Reference No:	2025/62/92747/E
Site Address:	land adj, 65, Huddersfield Road, Shelley, Huddersfield, HD8 8HG
Description:	Erection of outbuilding in field to rear
Recommending Officer:	Edward Cheseldine

Officer Report

FRONT 1:100

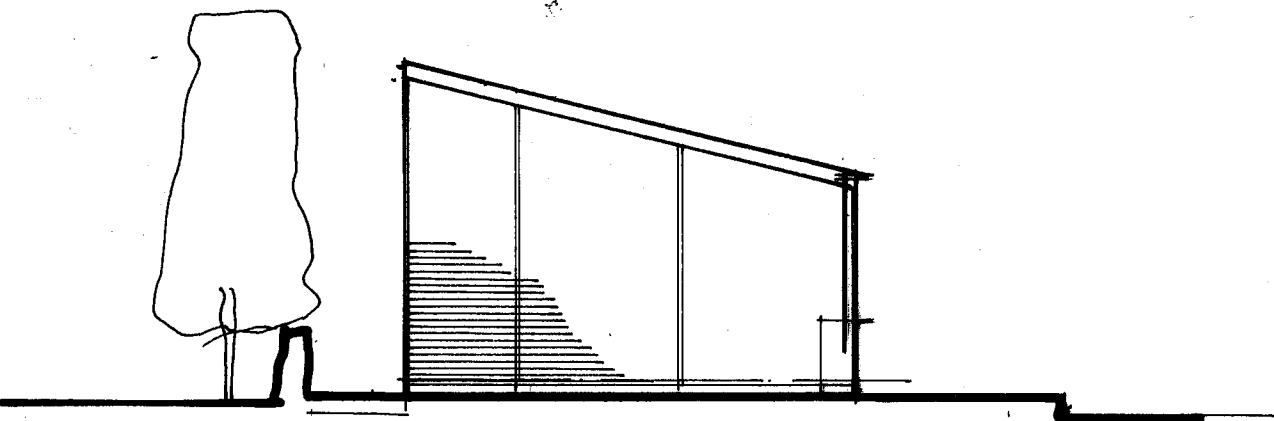
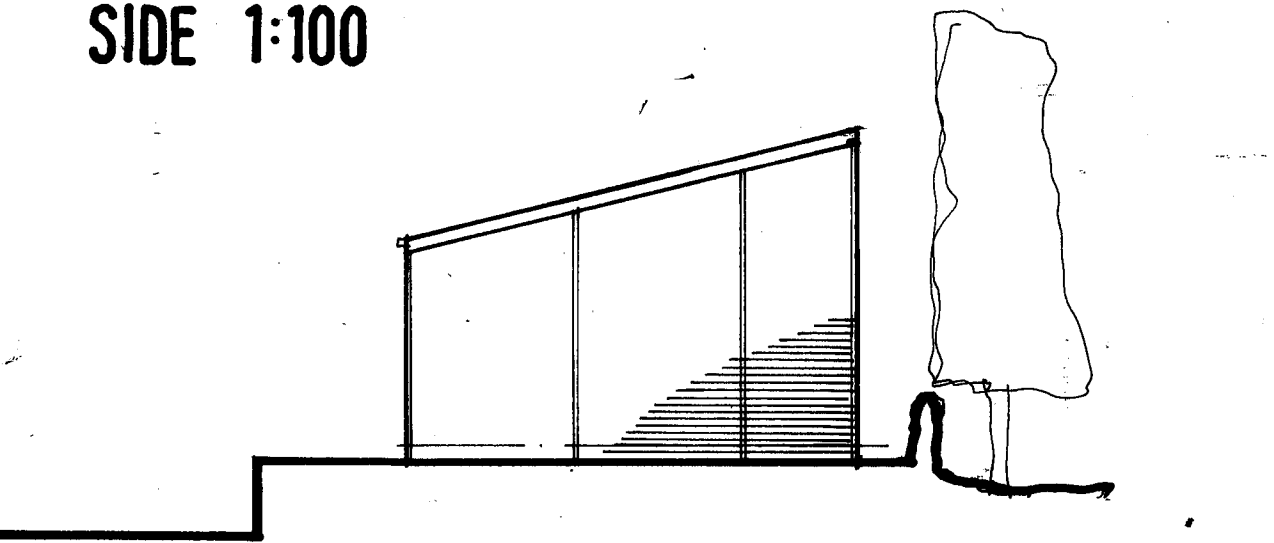
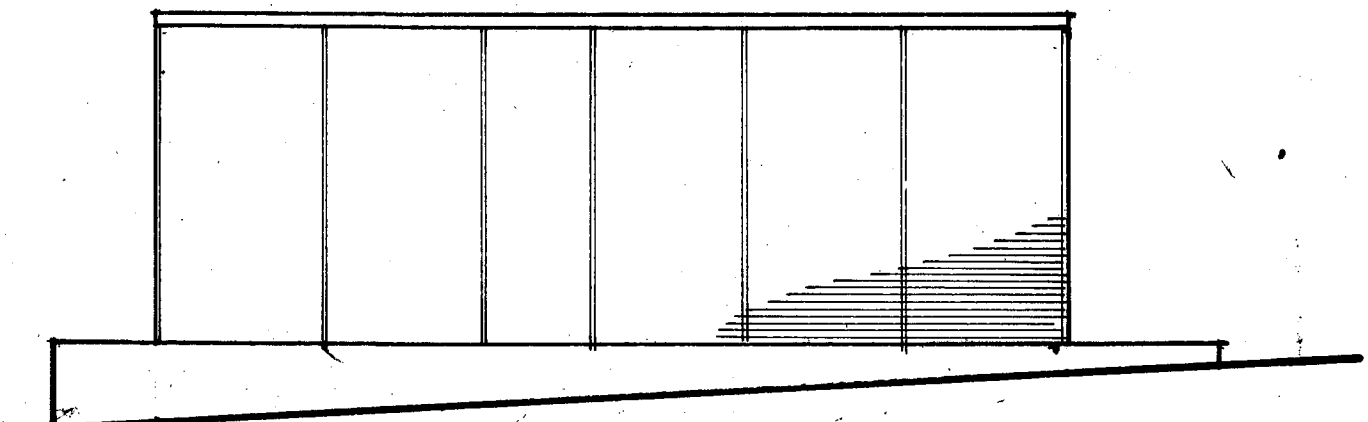
The proposed outbuilding would form a notable large structure within an open field measuring 12.00m width, 6.00m in length to a maximum height of 4.25m. Positioned 30.00m from the main dwellinghouse, it will appear visual detached from the host property and because of its considerable footprint and height, it would read more as a sizeable standalone structure. It would sit uncomfortably within a field setting. Its prominence is further enhanced by the height of the gabion foundation which it rests on.

Buildings located along Huddersfield Road are predominantly formed of natural stone which has weathered contrasting with the timber construction of the proposed building. There are no other timber buildings in the immediate vicinity. The change in palette will further add to the incongruity of the structure.

The building is visible from fleeting aspects along Huddersfield Road particularly when travelling southbound. Due to the size, elevated position and materials, the building would create a visually intrusive feature within the wider landscape.

The nearest residential property is located 19.80m from the proposed building, which is 69 Huddersfield Road. Windows are situated in the west facing elevation these windows do not look towards neighbouring outdoor space, therefore it is not considered that the relationship will impact privacy.

The building is located adjacent to the shared boundary. On the west side, the base of the building is drawn relative to the top of the stone boundary wall. On the east side, the base level is set at the height of the first course of the wall due to the landscaping works that have taken place. Land to the rear is a separate site not associated with 69 Huddersfield Road. The proposed structure is not considered to result in a loss of light, loss of outlook or an overbearing impact.

BLOCK PLAN 1:500

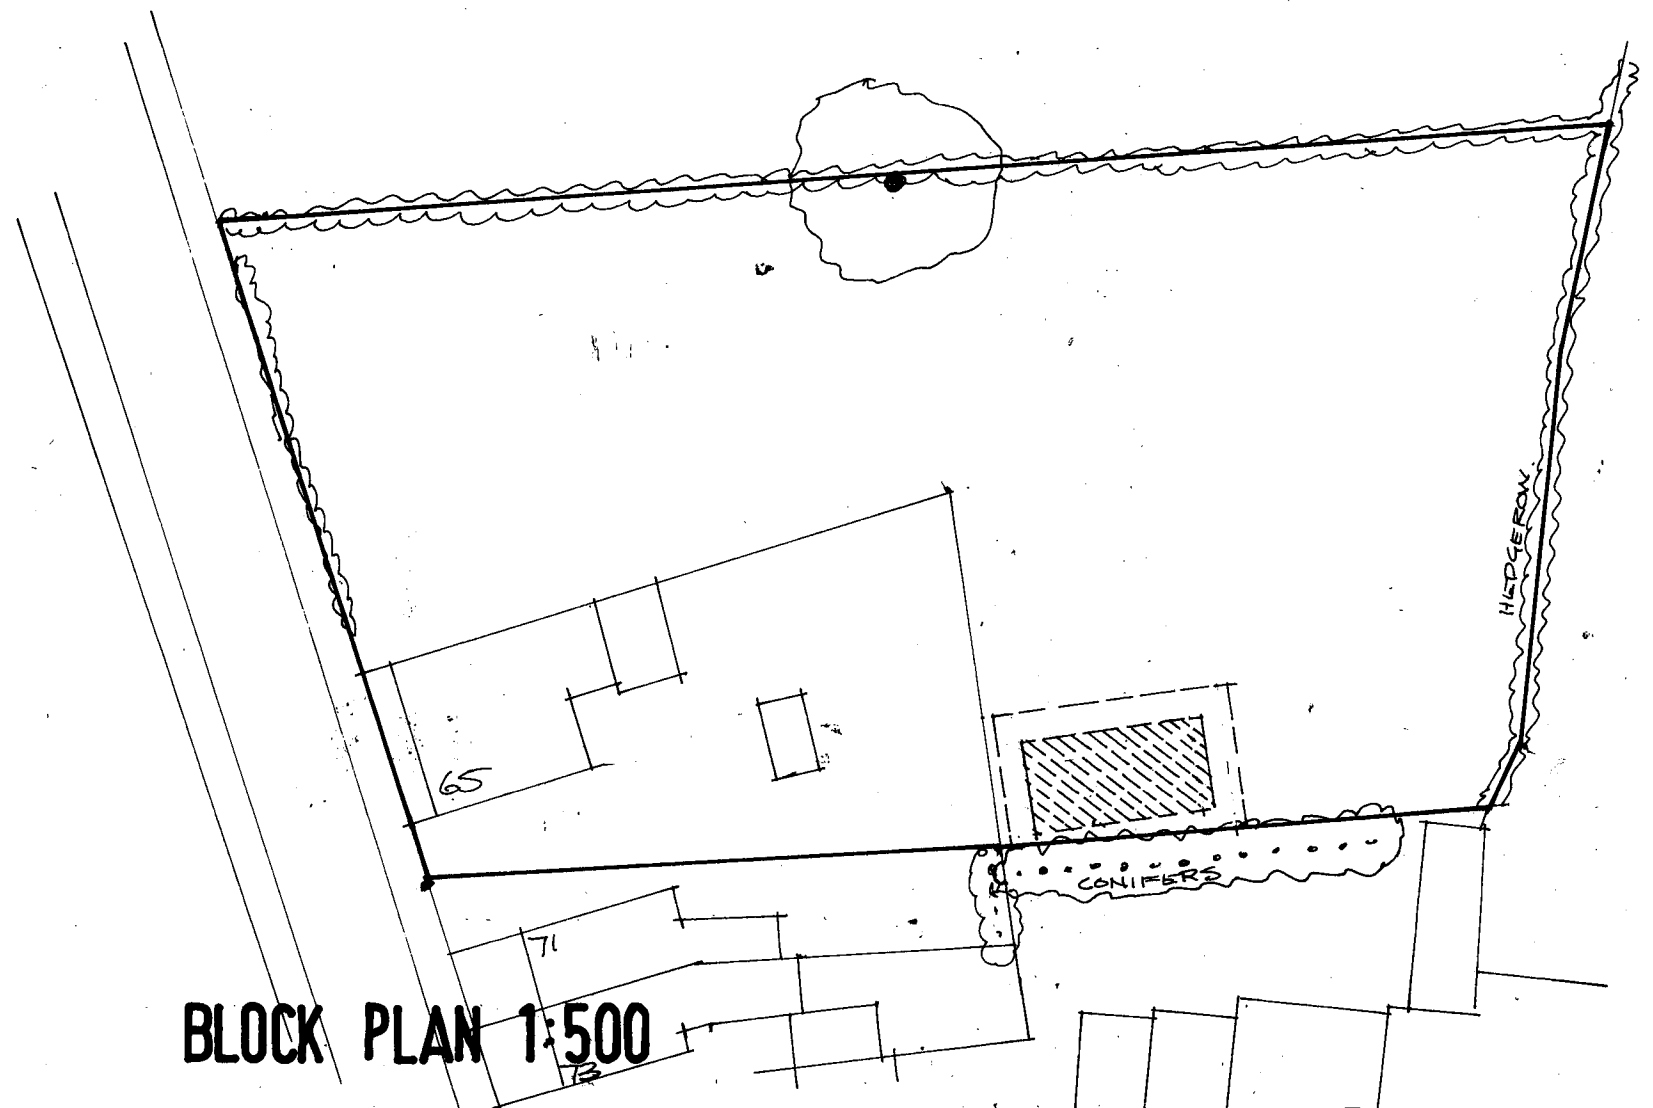
The curtilage of 65 Huddersfield Road was separated from the application site by fencing until recently. Aerial imagery confirms the separation between the land parcels has been removed.

The application site is currently free from any built form and contributes positively to the open and undeveloped character of the surrounding land. The proposed building will be used to as a garden room in connection with 65 Huddersfield Road. It will change the purposes of the land included within it through the placement of a domestic structure, landscaping and surface changes. The development of this open green space into a large building used in conjunction with the dwellinghouse would result in a significant visual change to the character of the land, resulting in urbanisation into an area that currently contributes to the openness of the Green Belt. This aspect of the proposal would result in an encroachment of built form into an area of previously open land and would therefore conflict with one of the fundamental purposes of including land within the Green Belt, as set out in paragraph 143 of the NPPF.

The application is for the erection of a building upon an area where no built form has stood. The proposal will therefore impact upon the openness of the Green Belt. It therefore cannot be stated that the application preserves the openness of the Green Belt as the outbuilding conflicts with the purposes as a result of encroachment into currently open land.
